City of Portland, Maine - Building or Use Permit Application
 389 Congress Street, 04101 Tel: (207) 874-8703, Fax: (207) 874-8716

Permit No: 08-0509	Issue Date:	CBL: 053 D007001
------------------------------	--------------------	----------------------------

Past Use: Maine Mecical - Parking Garage	Proposed Use: Maine Mecical - Parking Garage - New 20' x 4' 8" ½ banner	Permit Fee: \$220.00	Cost of Work: \$220.00	CEO District: 2
Proposed Project Description: New 20' x 4' 8" ½ banner		FIRE DEPT: <input type="checkbox"/> Approved <input type="checkbox"/> Denied	INSPECTION: Use Group: Type	
		Signature:	Signature:	
PEDESTRIAN ACTIVITIES DISTRICT (P.A.D.)				
Action <input type="checkbox"/> Approved <input type="checkbox"/> Approved w/Condition <input type="checkbox"/> Denied				
		Signature:	Date:

Location:	Portland, ME
Drawing No.:	1 of 2
Drawn by:	DS Rep.: PB
Date:	05.19.2008
Lead No.:	
Gen Ref.:

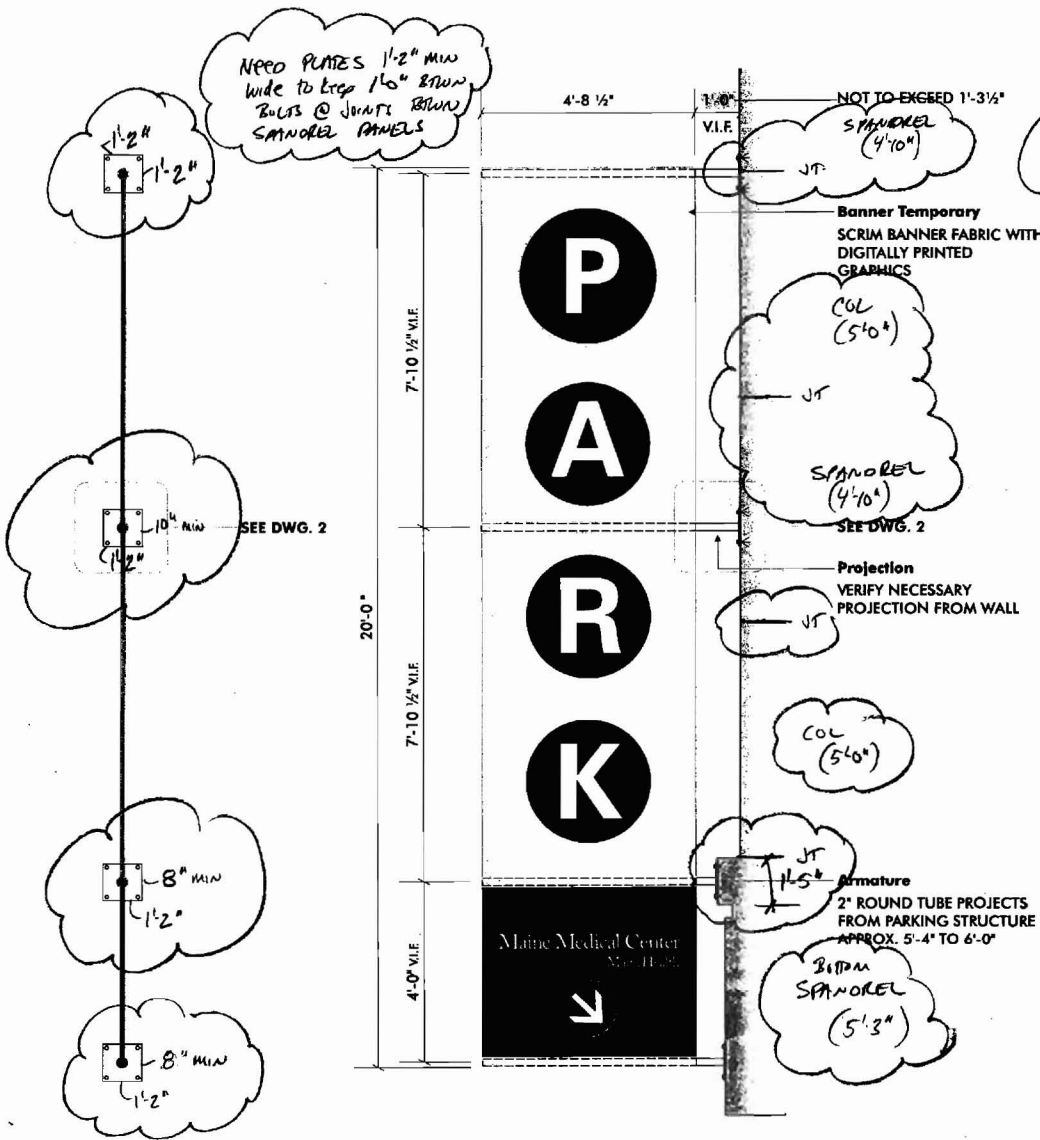
1) The approval is subject to the structural integrity of the banner and its means of being fixed to the building being documented to the City, including confirmation from a qualified Engineer that there is no possibility of failure (eg due to wind loadings or extreme weather conditions).

Building Inspections may wish to add a condition requiring that the installed banner be checked by a qualified engineer (at applicants expense) so that it is confirmed that the installation has been done so that the banner does not pose a potential safety hazard to the public.

5/22/2008-jmb: Received detail from NeoKraft that was reviewed by structural engineer Mike Bolduc based on fastening calcs, ok to issue
